# CITY OF ALBUQUERQUE

March 20, 2014

**Re: Pulte@ Mirehaven Phase 1 Grading Plan**  
**Engineer's Stamp Date Sheet 1: 12-19-13, Sheet 2: 3-12-14, Sheet 3: 3-12-14,**  
**Sheet 4: 12-19-13, Sheet 5: 1-23-14, Sheet 6: 1-23-14 (H09D017B)**

PULTE @ MIREHAVEN PHASE 1
GRADING PLAN

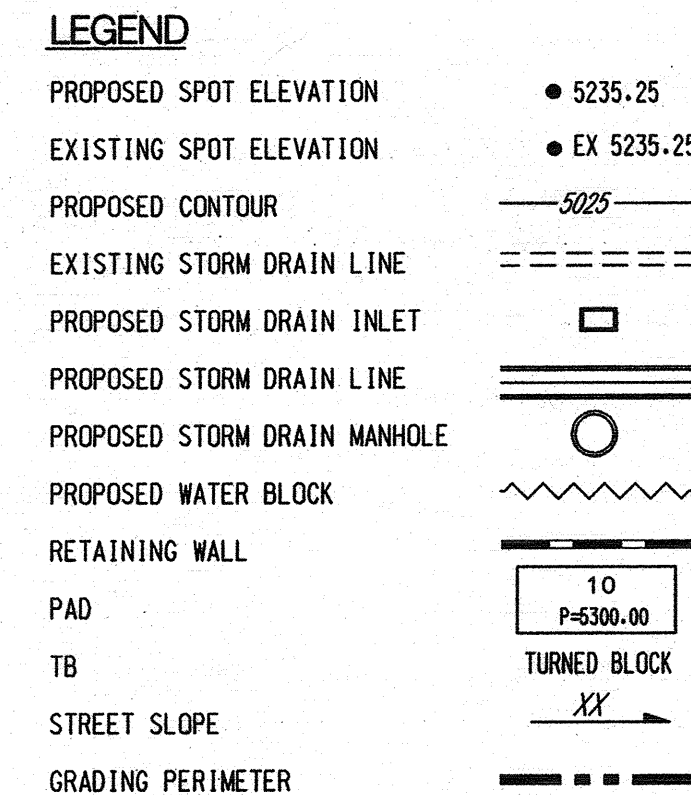
The angled horizontal alignment of the storm drain shown on Sheet 2 is subject to approval at DRC.

CITY PROJECT NO.	ZONE MAP NO.	SHEET	OF
		5	6

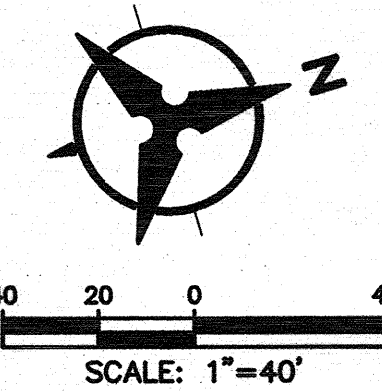
The high point in the open space between Lots 36 and 37 as shown on Sheet 5 is expected to be followed on Sheet 6, where it is not shown.
